SECTION 4.55(1A) MODIFICATION APPLICATION (SSD 7173 MOD 6) FOR PROPOSED AMENDMENT TO THE SUBDIVISION PLAN

PROPERTY AT: 585-649 MAMRE ROAD, ORCHARD HILLS (LOT 2171 DP 1153854)

Table 1: Response Matrix

JOB TITLE PLAN OF PROPOSED SUBDIVISION OF LOT 8 DP271141 ERSKINE PARK			Plan No.: 73535.008 VER 7
Reduction Ratio: 1:3000	Date of Survey: N/A	Surveyor: GKO Drawn By: SHL	Sheet 2 of 2

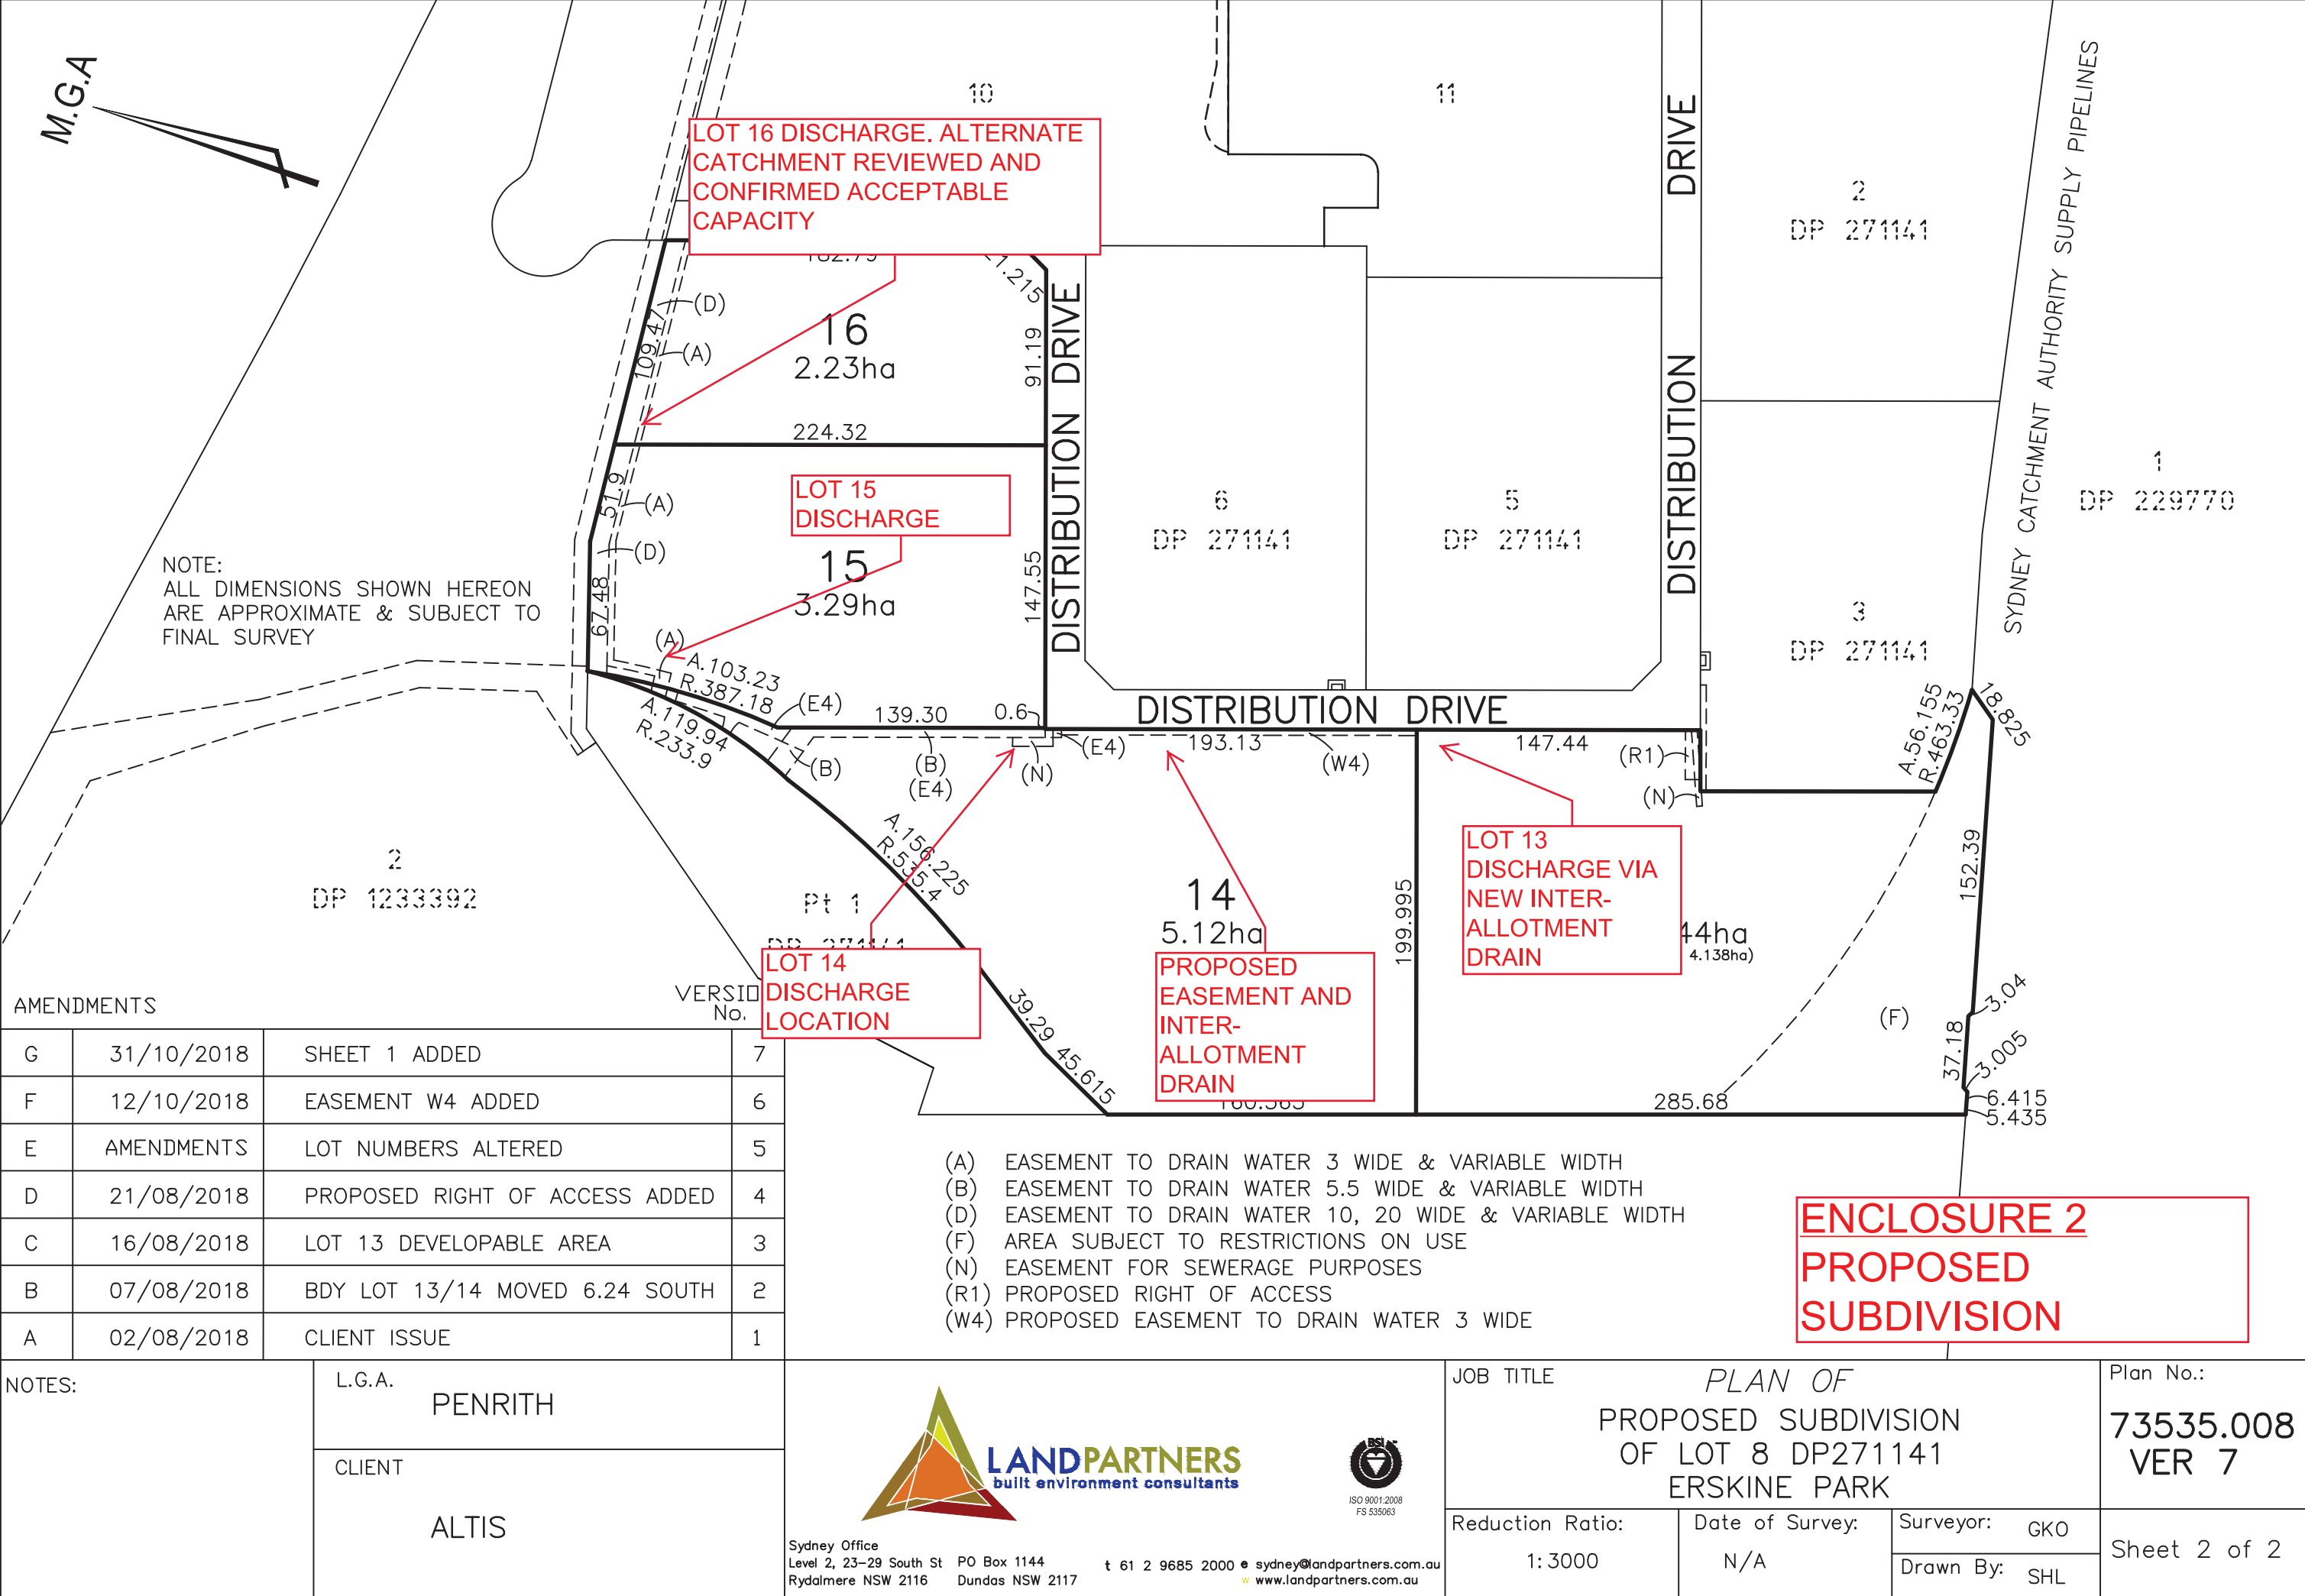
For this Modification (MOD 6) it is noted all stormwater management outcomes will be generally consistent with that approved under SSD 7173. It is important these conditions are fully implemented in the areas immediately adjacent to the Pipelines corridor, and the area notated (F) on the amended subdivision plan (Sheet 2; Plan No. 73535.008 Ver 7; 31/10/2018) continues to be identified as being restricted in use.

WaterNSW (Malcolm Hughes – Manager Catchment Protection)	
<p><i>WaterNSW has previously responded to the original application and subsequent MOD 3 for this site. No requests to provide comment on MODs 1, 2, 4 or 5 were received by WaterNSW, however it is noted the nature and locations of the Modifications were such that the potential to impact the Pipelines corridor was low.</i></p> <p><i>In our response to the original SSD (31 May 2016; D2016/41889) the south-west corner of the site was to be excluded from development as a result of flood concerns. It was noted this area is currently used to convey stormwater from the Pipelines corridor, which forms the southern boundary of the site. WaterNSW requires that the flow of stormwater from the Pipelines corridor must not be impeded or caused to flow back to the corridor. The determination conditions C25, C26 and C27 reflected</i></p>	<p>Noted and agreed. No further action required.</p>

**ENCLOSURE 3
CATCHMENT PLAN**

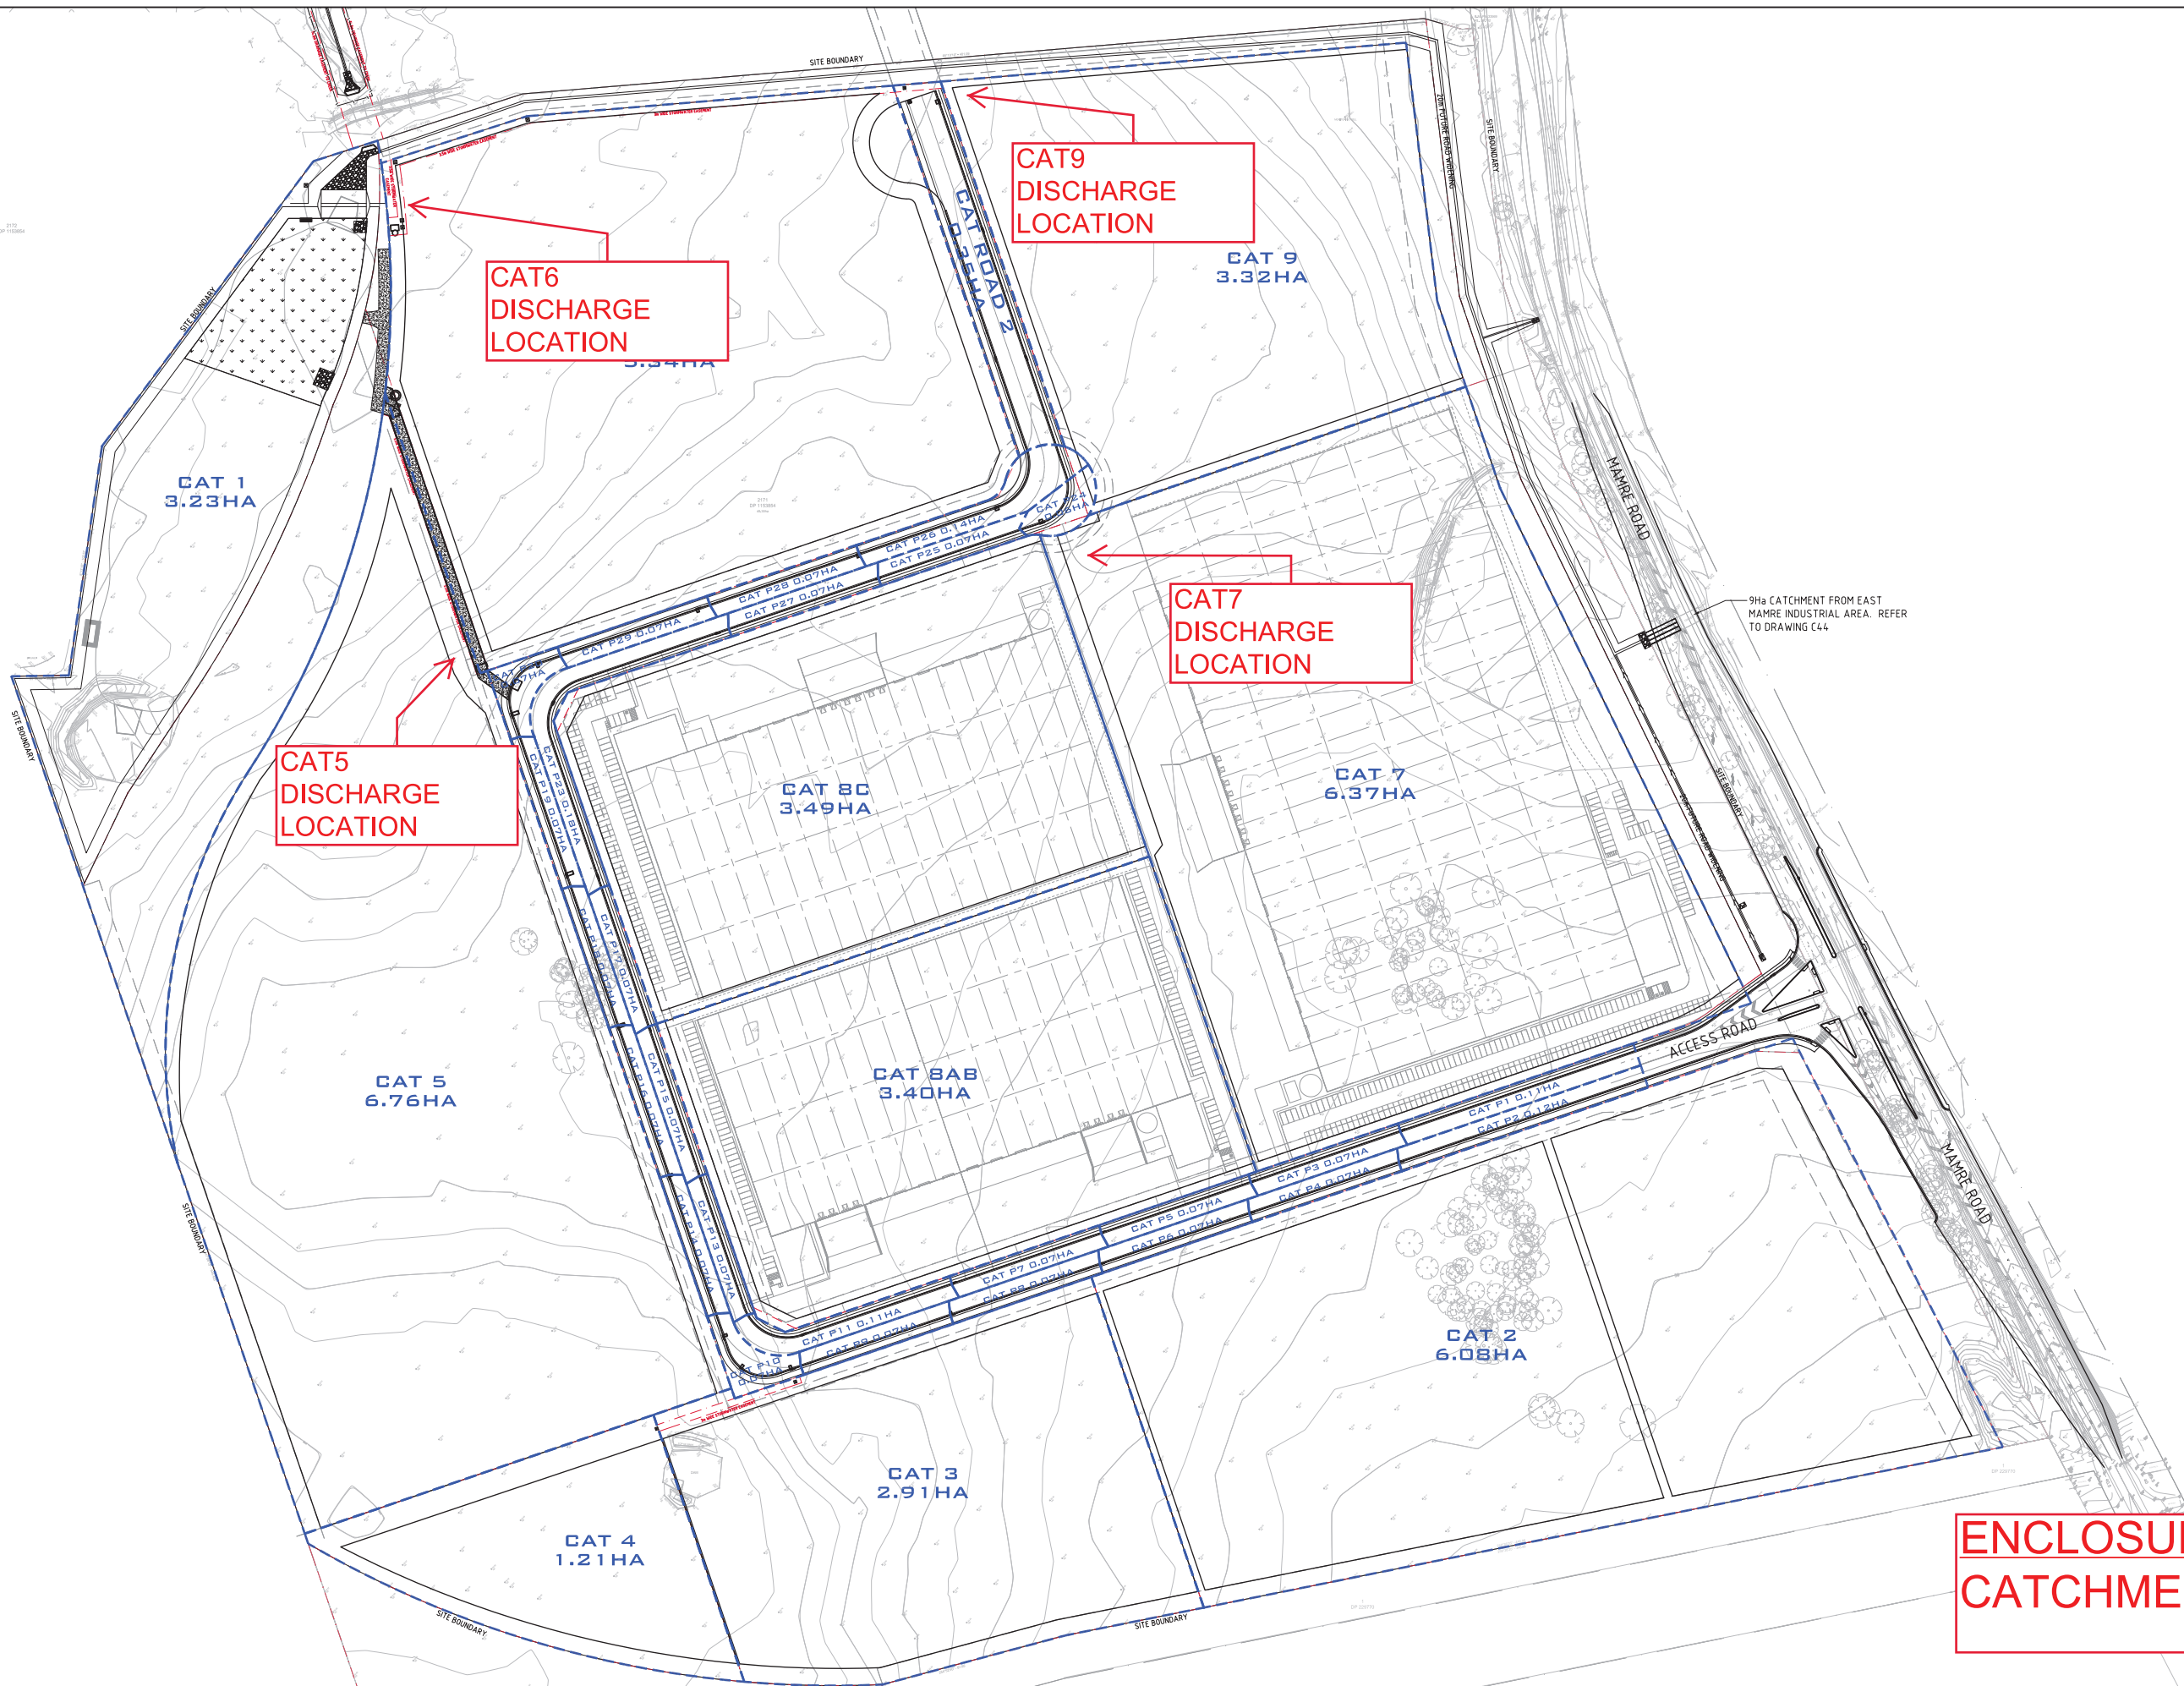
Relevant Entities Response to Submissions	Formalised Response
Penrith City Council (Gavin Cherry – Development Assessment Coordinator)	
<p><i>Engineering and Drainage Design Detail</i></p> <p><i>The proposed Civil & Stormwater Plans as submitted are not civil design drawings and appear to be a copy of subdivision plans with hand written drainage notes.</i></p> <p><i>Detailed civil design drawings indicating all proposed drainage works with level notations and associated contours is required to be submitted to enable adequate assessment of the modification application in accordance with Council's 'Design Guidelines for Engineering Works for Submission and Developments'.</i></p>	<p>The Civil Engineering (Stormwater) Letter of Support (refer to Appendix 1), provided by Costin Roe Consulting has been amended to remove any hand-written drainage notes, for which detailed civil engineering plans have been incorporated accordingly. Appendix 1 is considered to satisfactorily address the proposed amendments to the Subdivision Plan with regard to proposed Lots 13-16.</p> <p>Under this Modification Application there are no drainage works proposed. Proposed lots 15 & 16 will operate as previously approved by Council with regard DA18/0628 (proposed Lot 16) and DA18/0689 (proposed Lot 15). Furthermore, proposed Lots 13 & 14 will remain as previously approved under SSD 7173 MOD 2 (refer to Appendix 3).</p> <p>Additionally, there will be no changes to the contours and levels on Lot 8 (proposed Lots 13-16) (refer to Appendix 2).</p> <p>No further consideration is considered warranted.</p>
